Application Ref:	3/2021/0319	 Ribble Valley Borough Council www.ribblevalley.gov.uk
Date Inspected:	22/04/2021 and 20/05/2021	
Officer:	AD	
DELEGATED ITEM FILE REPORT:		Decision Refusal

Development Description:	Design amendments to previous approvals 3/2018/0455 and 3/2019/0467 for one 3 storey dwelling.
Site Address/Location:	Land Adjacent to 39 Clitheroe Road Whalley BB7 9AD

Drawing Title Proposed Floor Plans		
Scale 1:100 @ A1	Date March 21	Drawn RBM

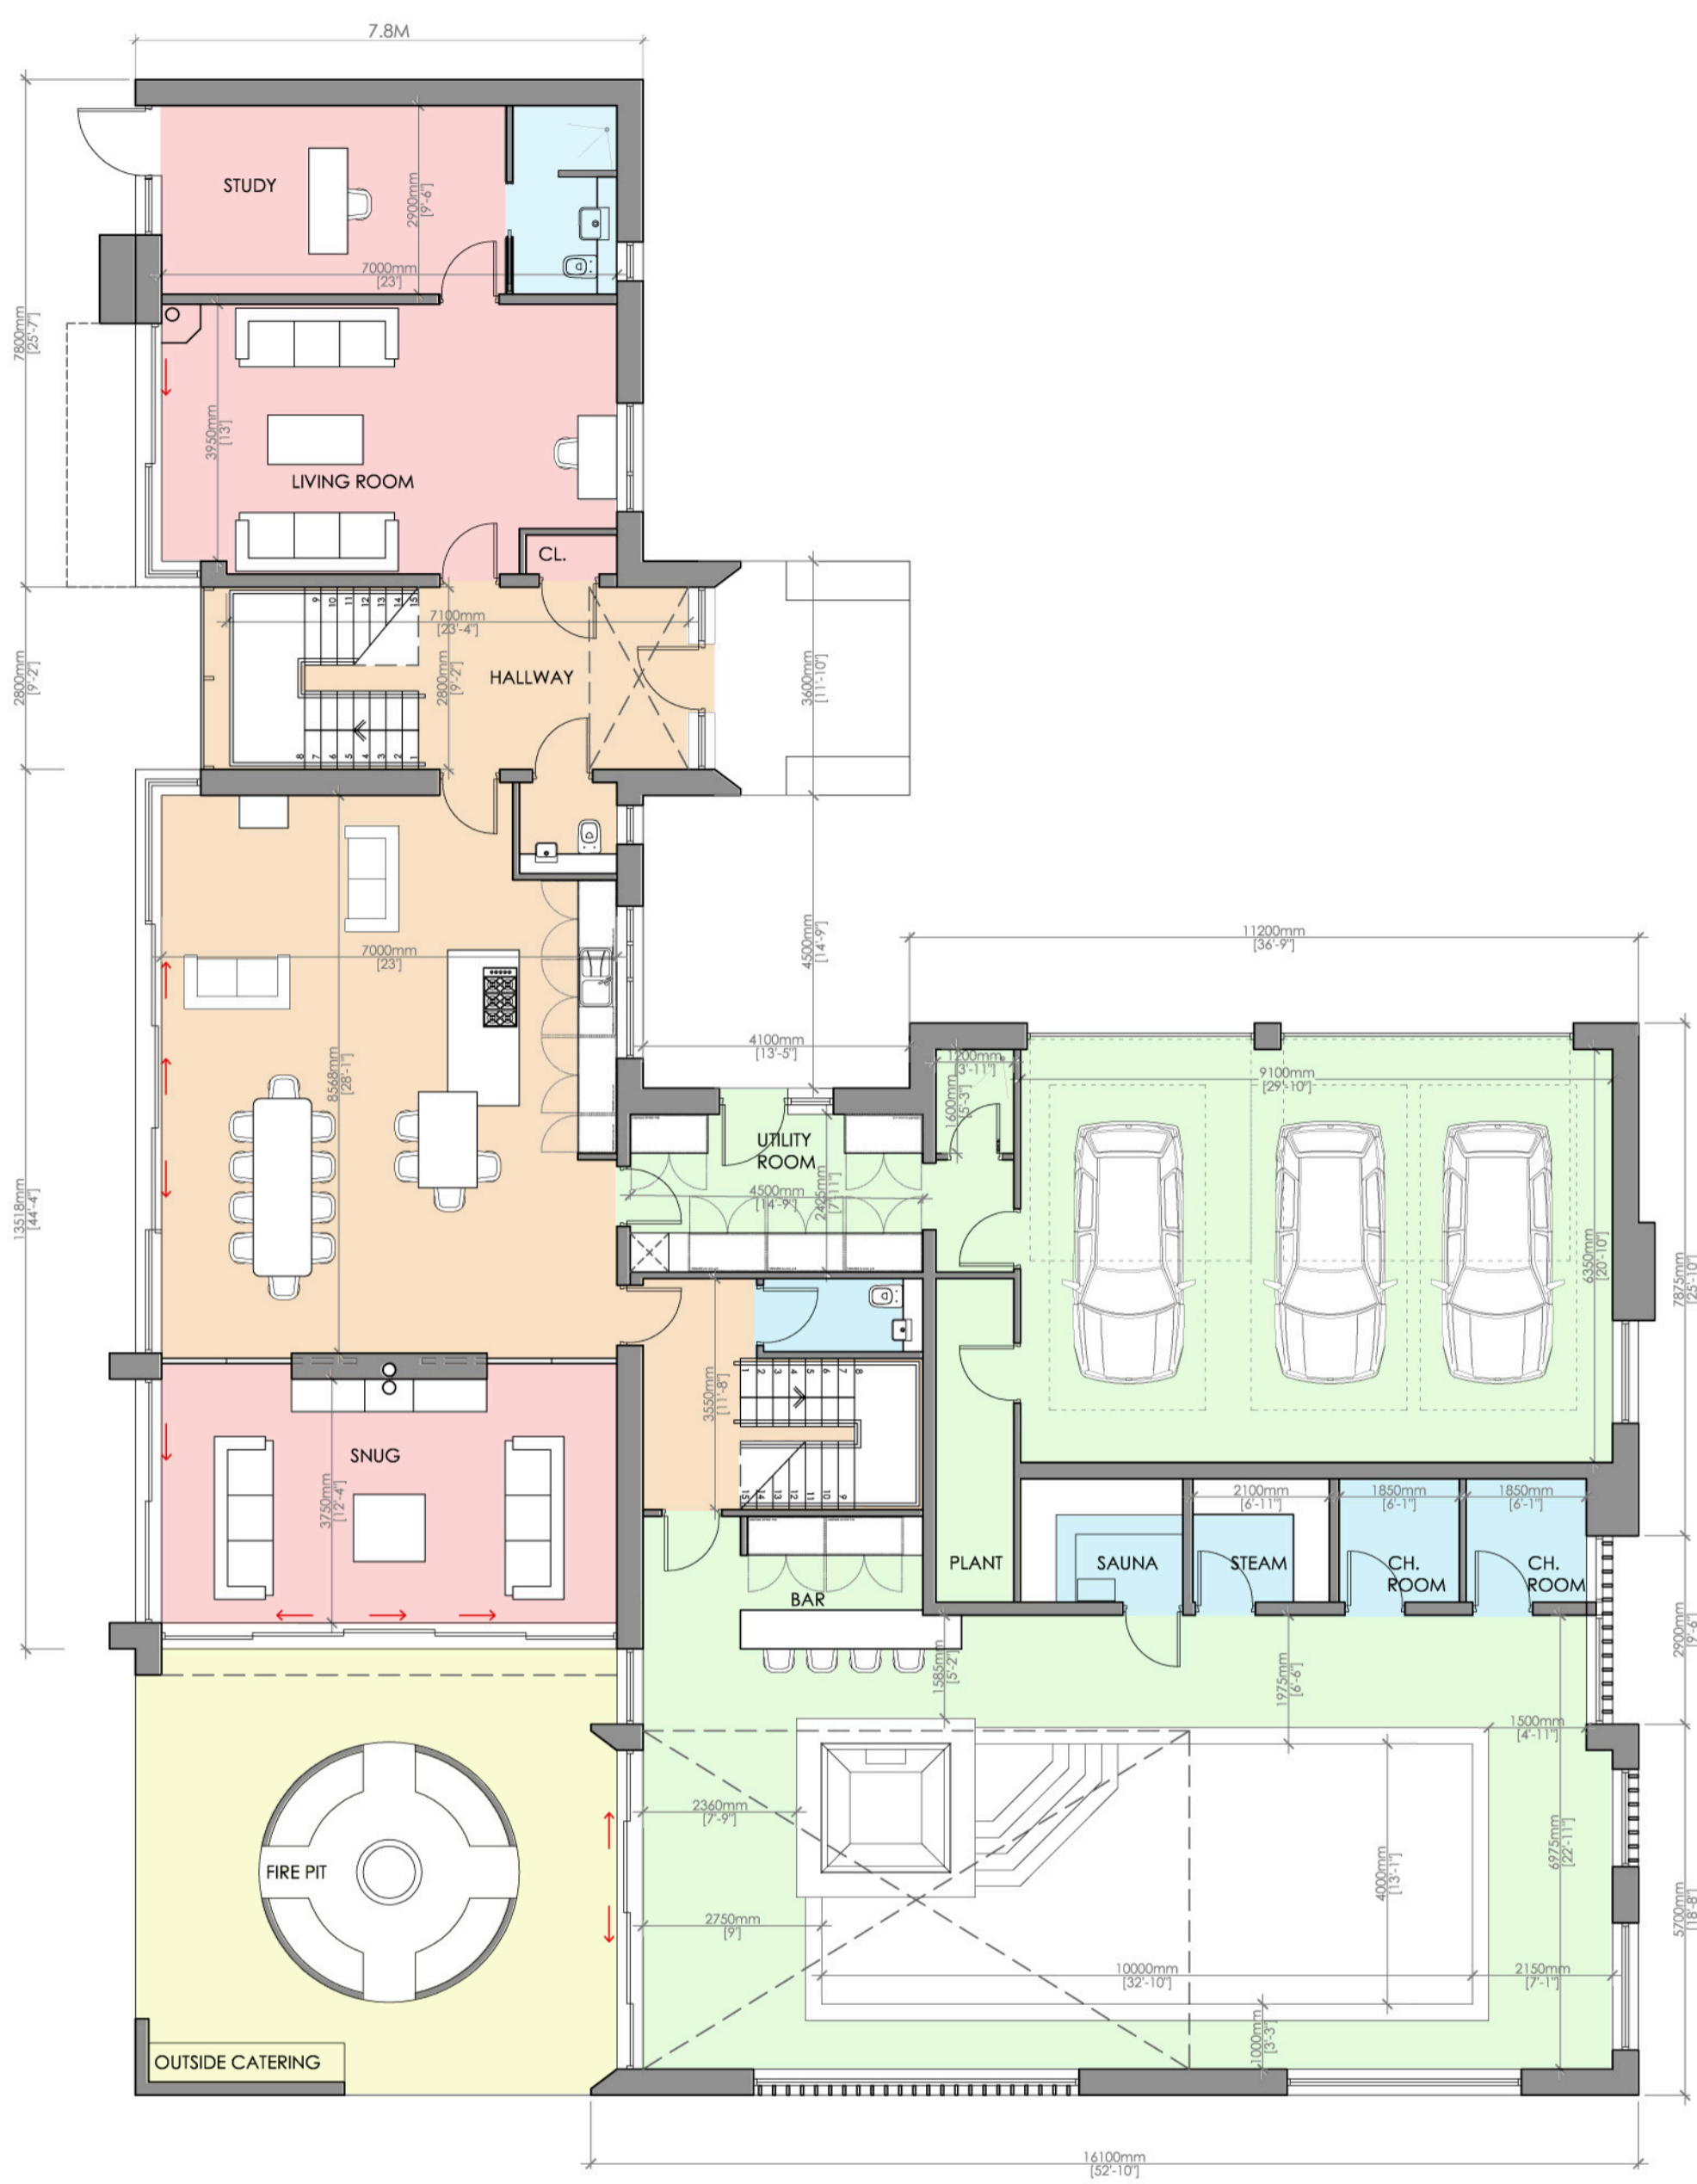
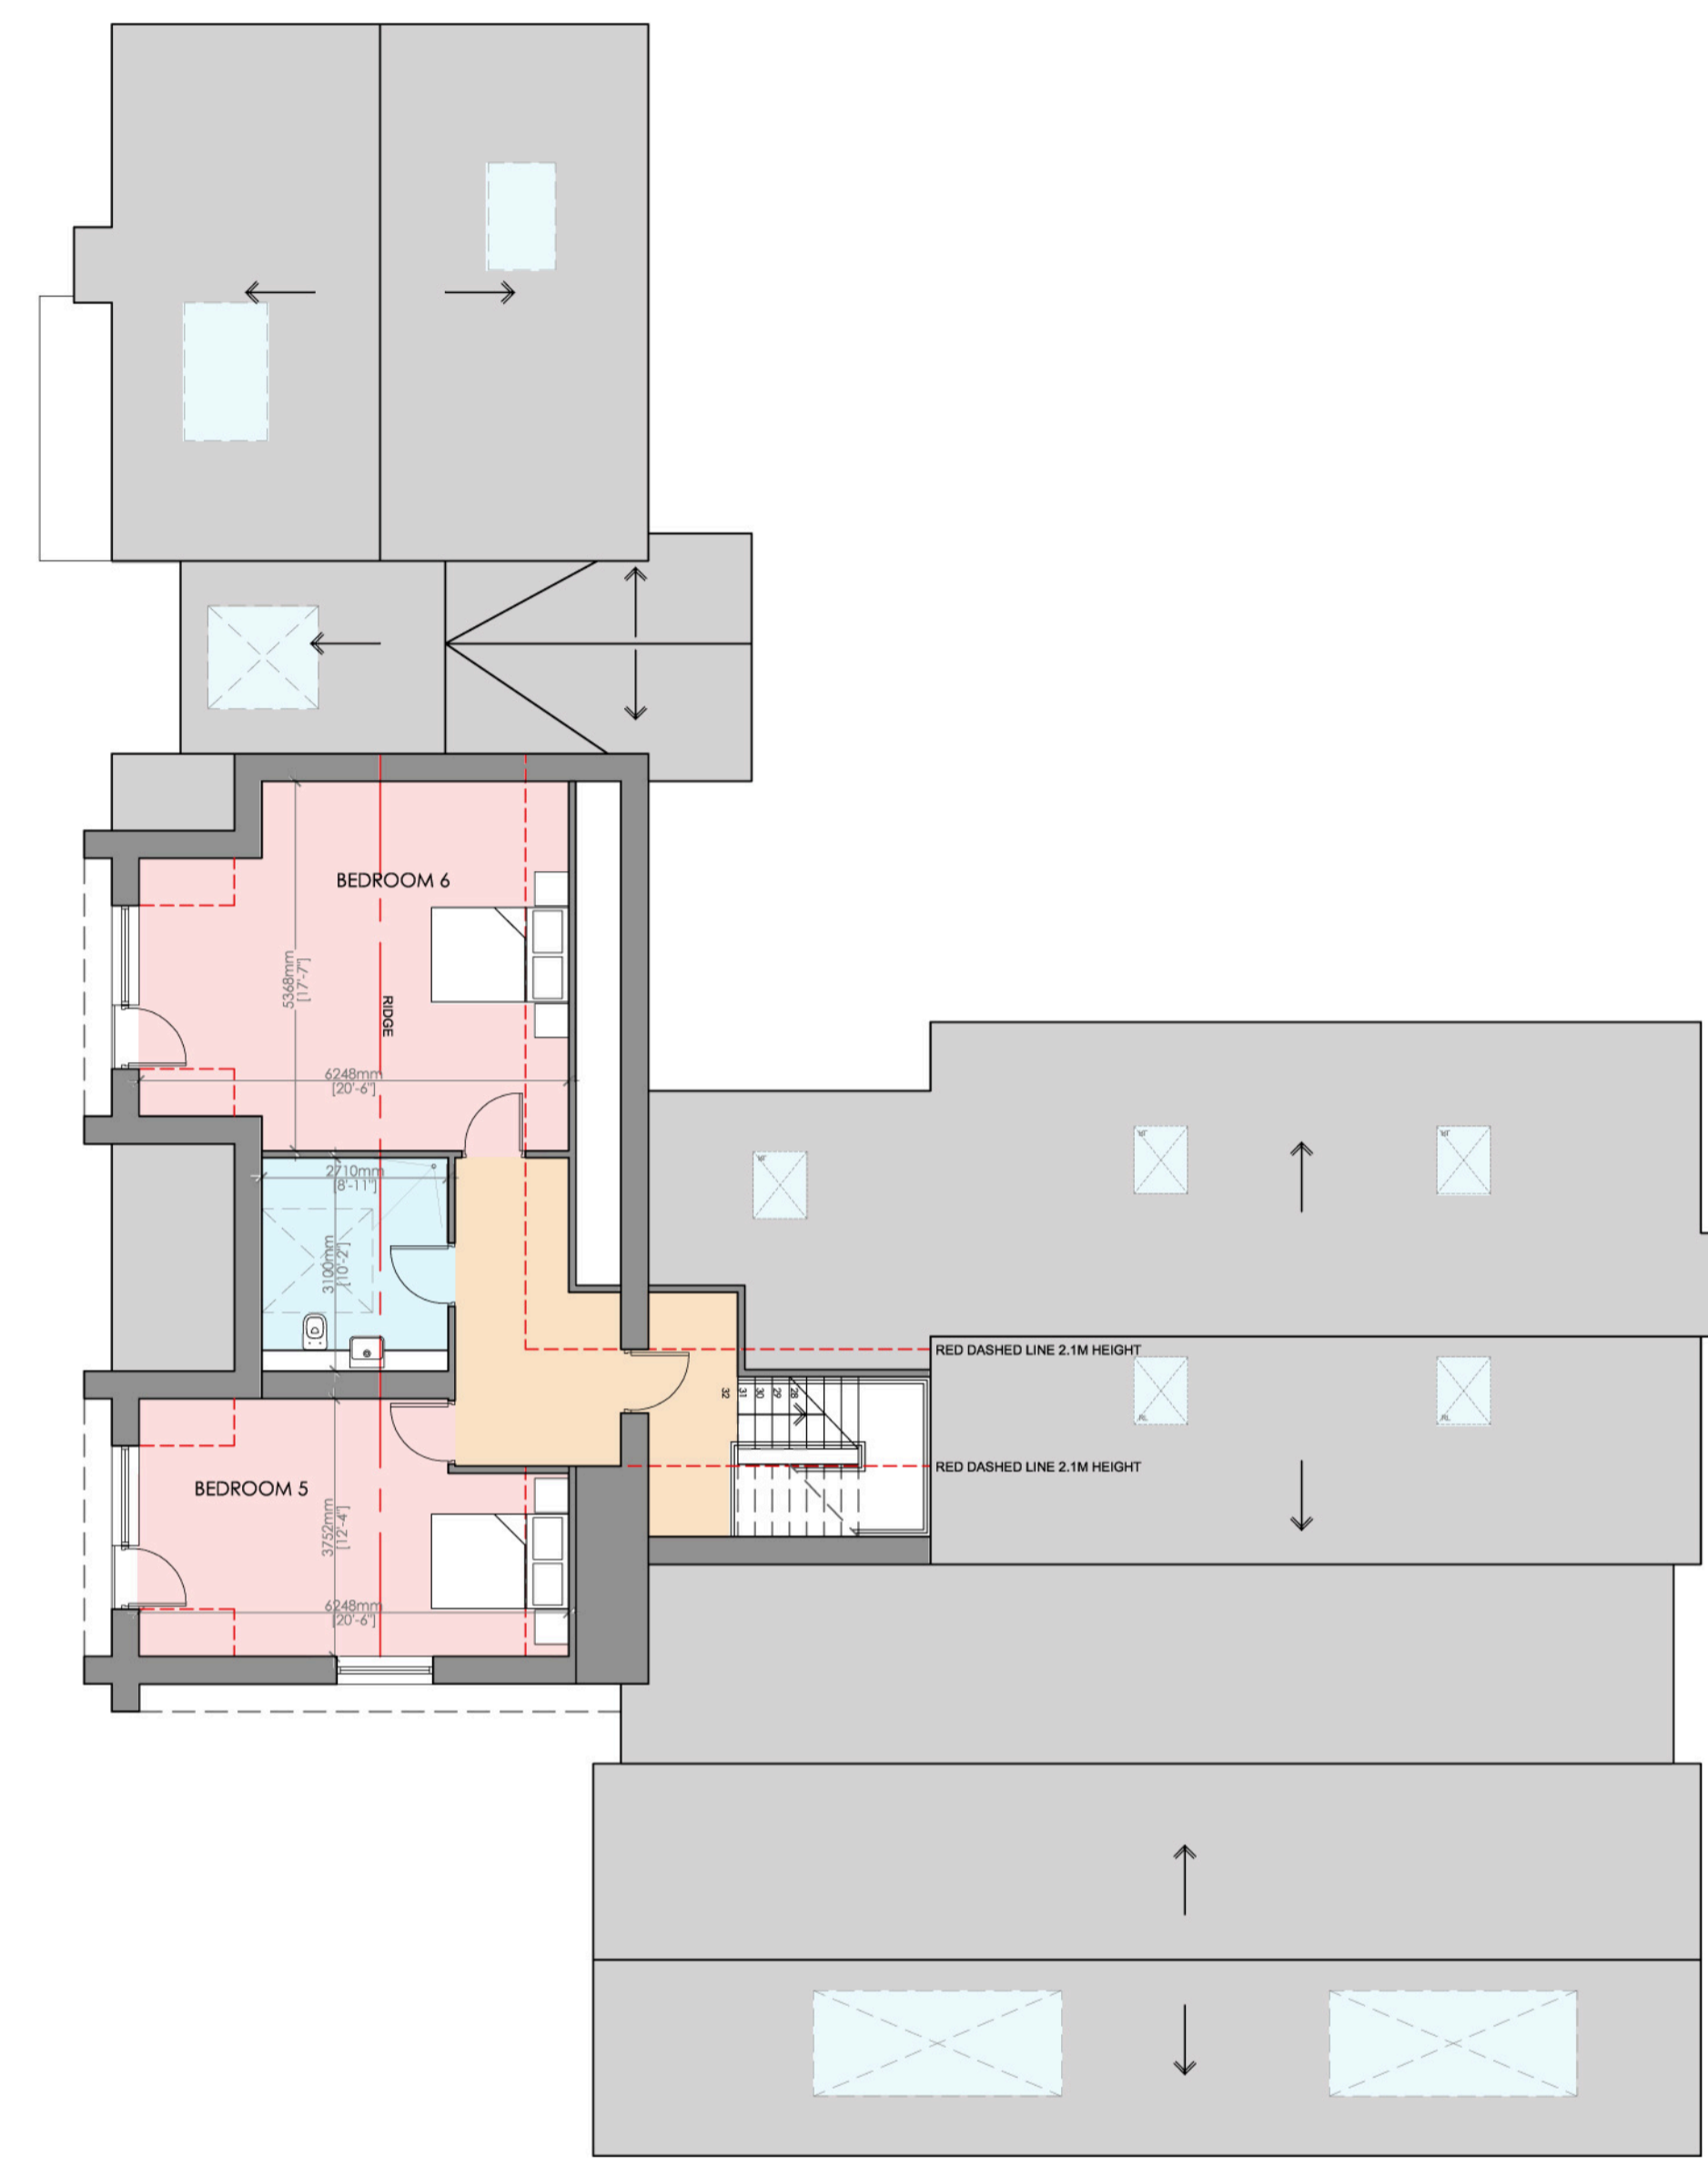
Planning permission is sought for “design amendments” to both previous reserved matters approvals. This includes an increase in height (including three storey elements), a new swimming pool/gym block, new rooflights, new fenestration types and glazed gables (west elevation).

- The multiplicity of window shapes and styles. Triangular -based (used only in the east elevation atrium previously), rhomboid and horizontally emphasised windows are not part of the vernacular and contrast to the contemporary but vertically emphasised (including horizontal windows broken into vertical lights) windows in 3/2018/0455;
- Rooflights (mostly horizontally-emphasised) and high level triangular - glazed apexes are conspicuous and break-up roof lines which are an important counter - balance to the high degree of fenestration (and high void:solid ratio) below;
- The swimming pool/gym building. Whilst the Proposed Site Plan suggests this to be stand-alone, the block and elevation plans show it to be a wing. This appears to be poorly articulated with the rest of the build because of its flat roof link, fenestration and contrasting materials (non-vernacular burnt timber).

That planning permission be refused for the following reason:
The proposed development is harmful to the character and appearance of the area including the Clitheroe Road streetscene because of its fenestration (including conspicuous and incongruous triangular-based, rhomboid and horizontally emphasised windows), roofscape (including conspicuous and incongruous horizontally-emphasised rooflights and glazed apexes) and conspicuous and incongruous swimming pool/gym wing (flat roof link, fenestration and materials). This is contrary to Policy DMG1 of the Ribble Valley Core Strategy.
